WEST SUSSEX COUNTY COUNCIL
HIGHWAYS AND TRANSPORT SERVICES CONSULTATION

SUBJECT: BR/184/08/A - 2 x externally illuminated fascia signs and 1 x internally illuminated projecting sign

152-156, Hawthorn Road, Bognor Regis, West Sussex

SIGNAGE DETAILS

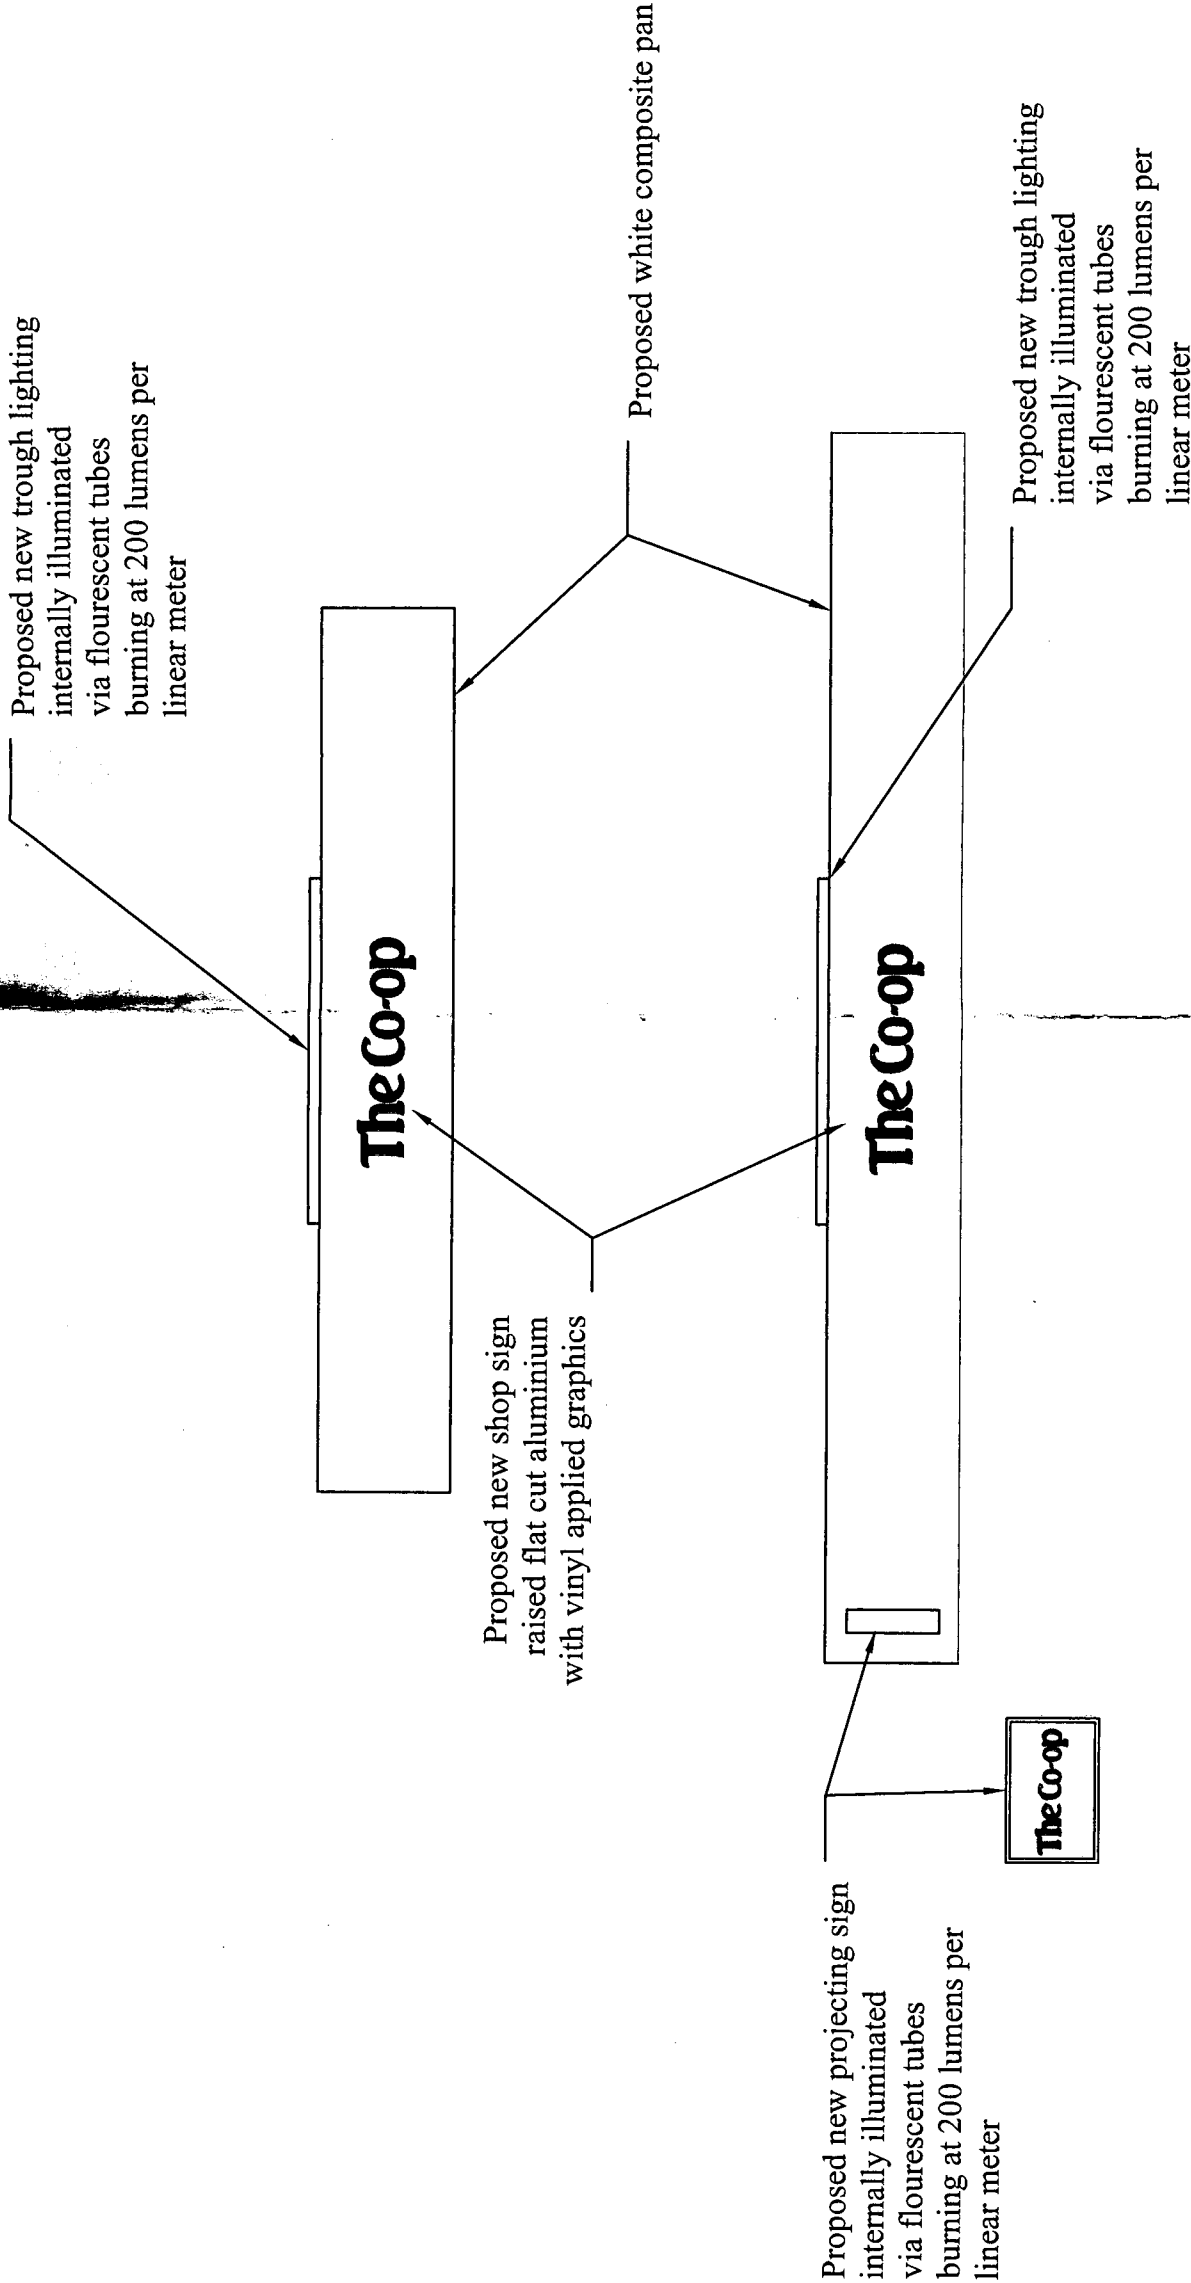
Upon inspection of the plans, the proposed signs would not appear to be in a location where they could obstruct the highway. The signs are not expected to restrict visibility along Hawthorn Road. The proposed signs are not located within the publicly maintainable highway.

PROPOSED ELEVATIONS 1:100

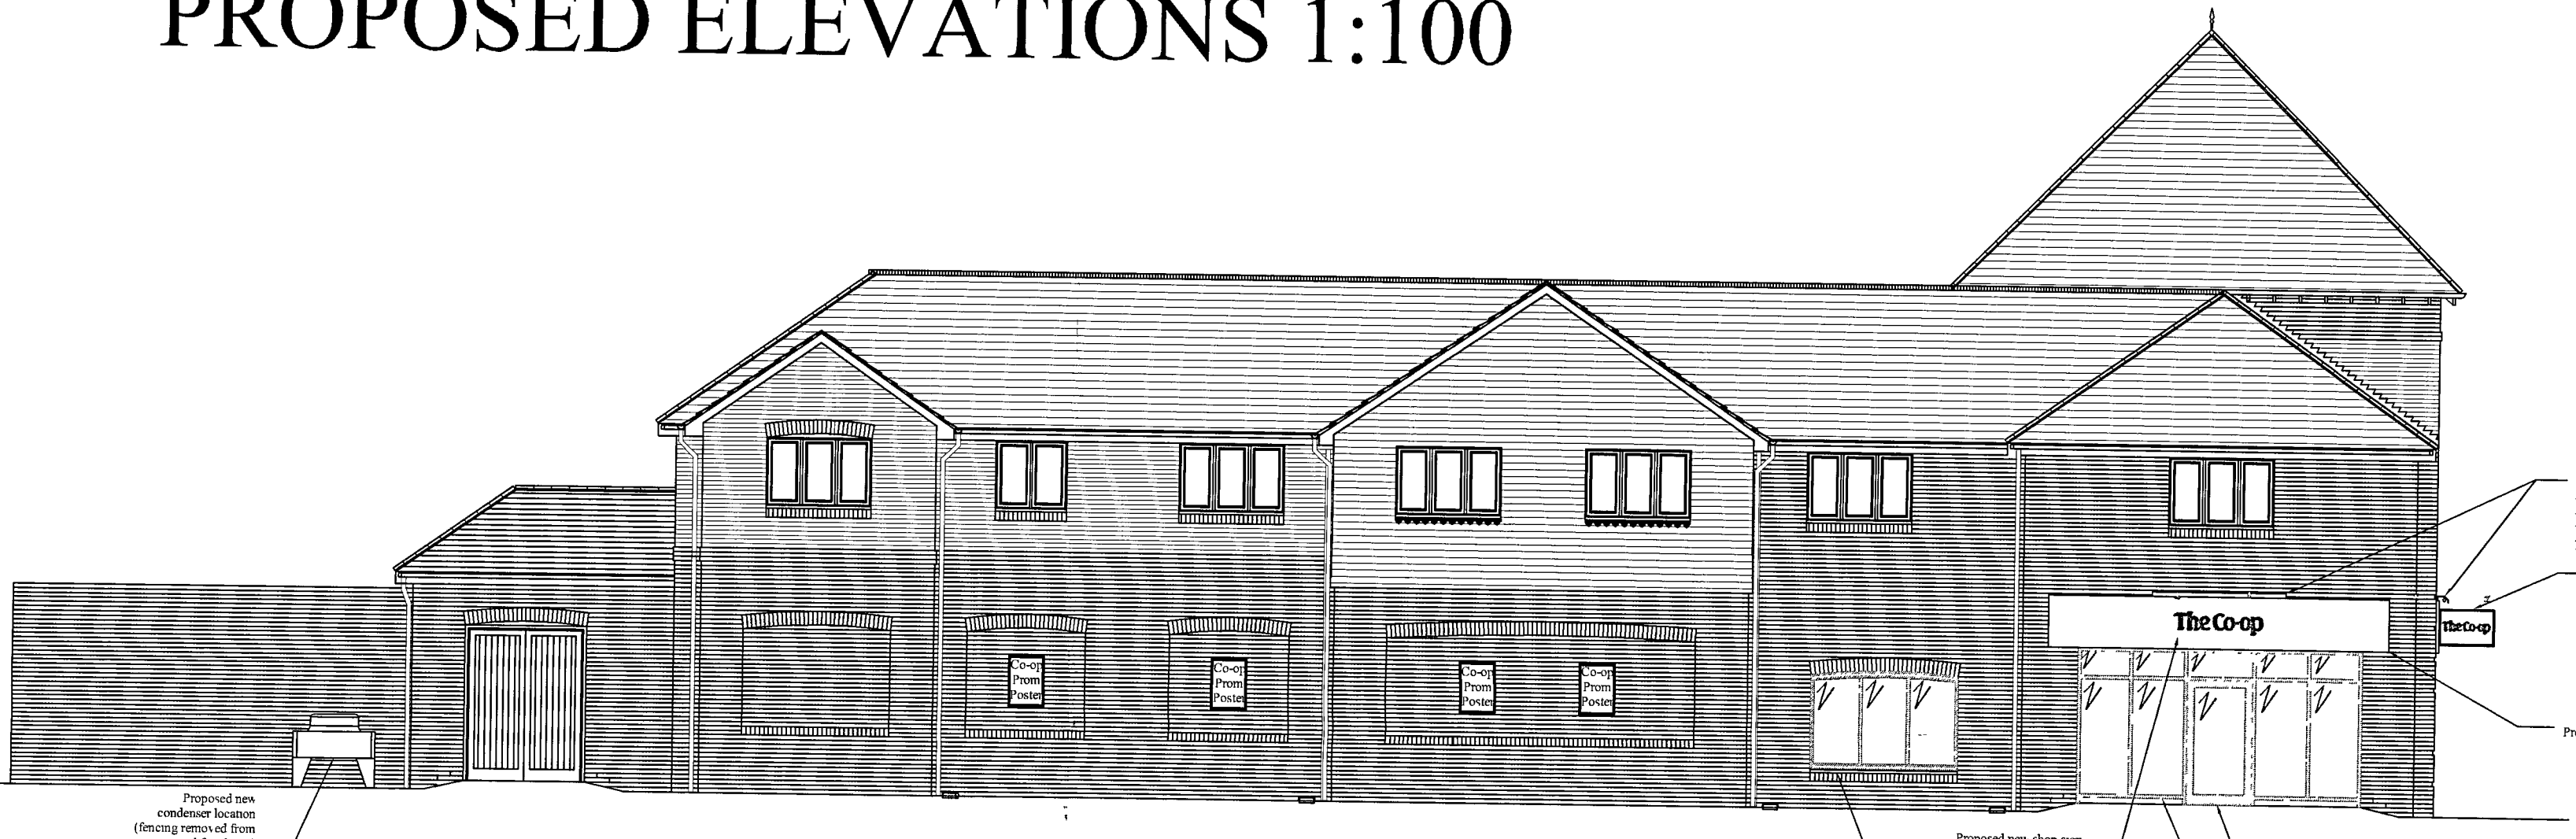
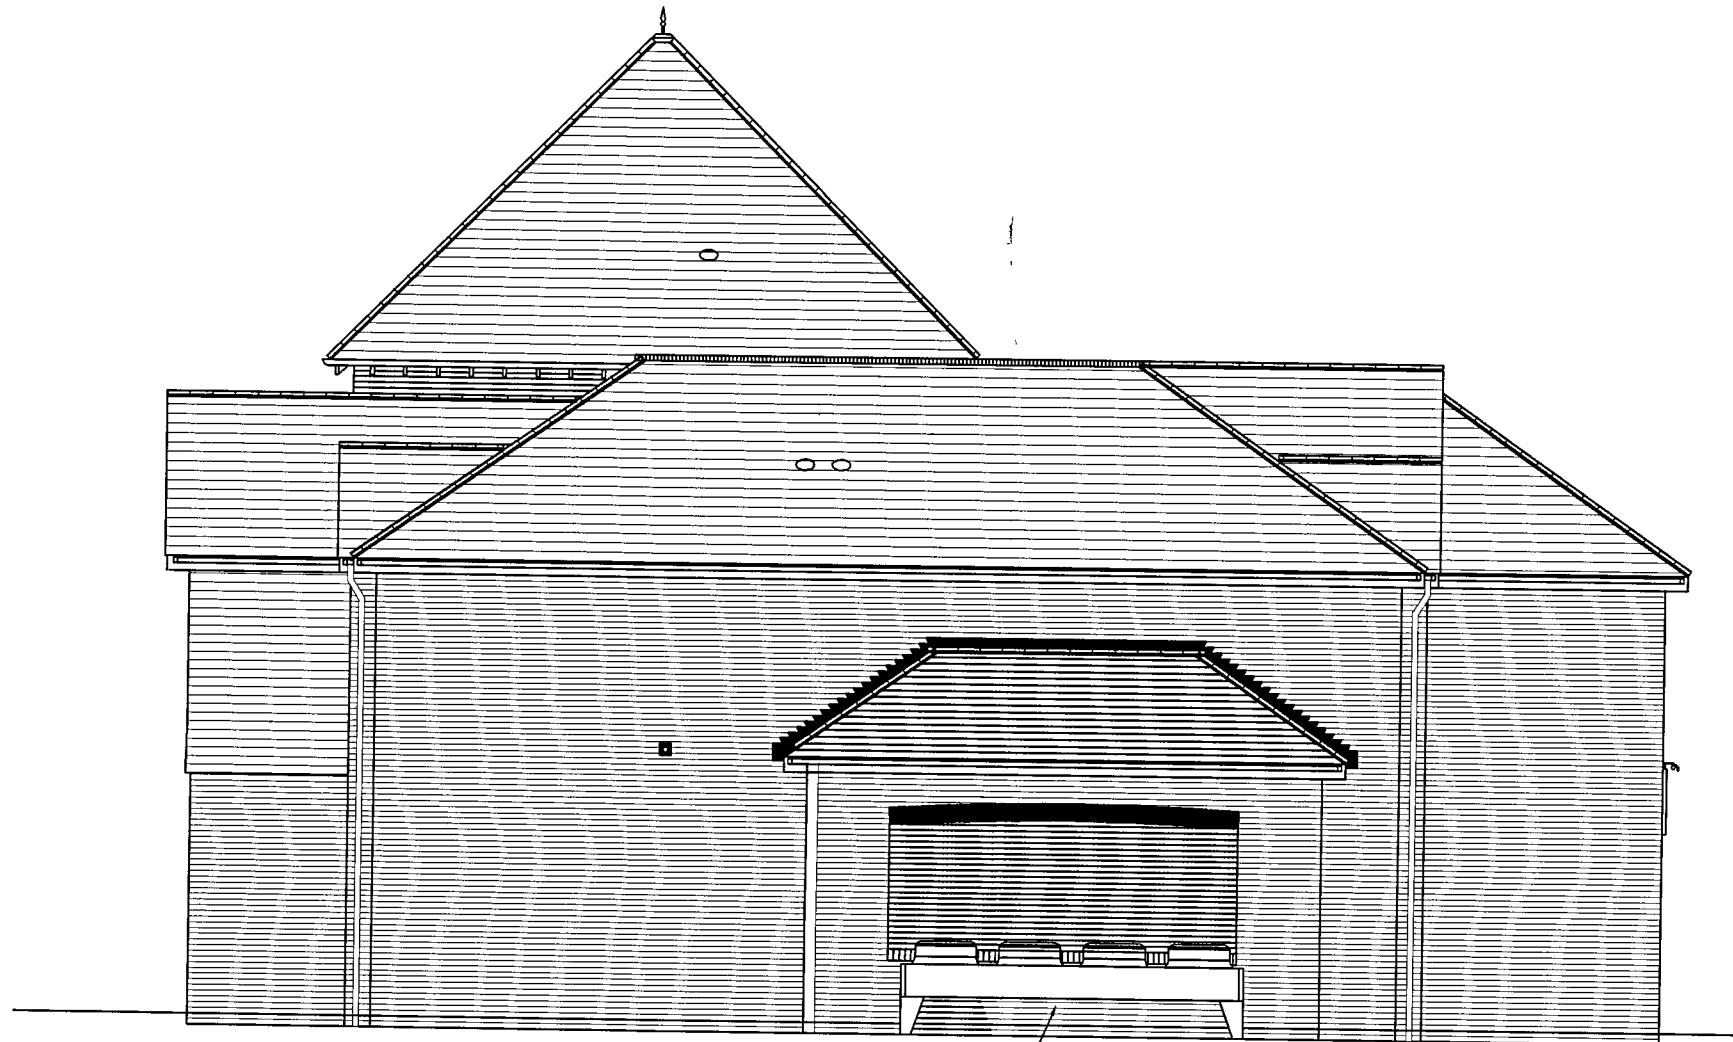
The applicant is reminded that the height of the projecting sign should be a minimum of 2.4 metres above the footway.
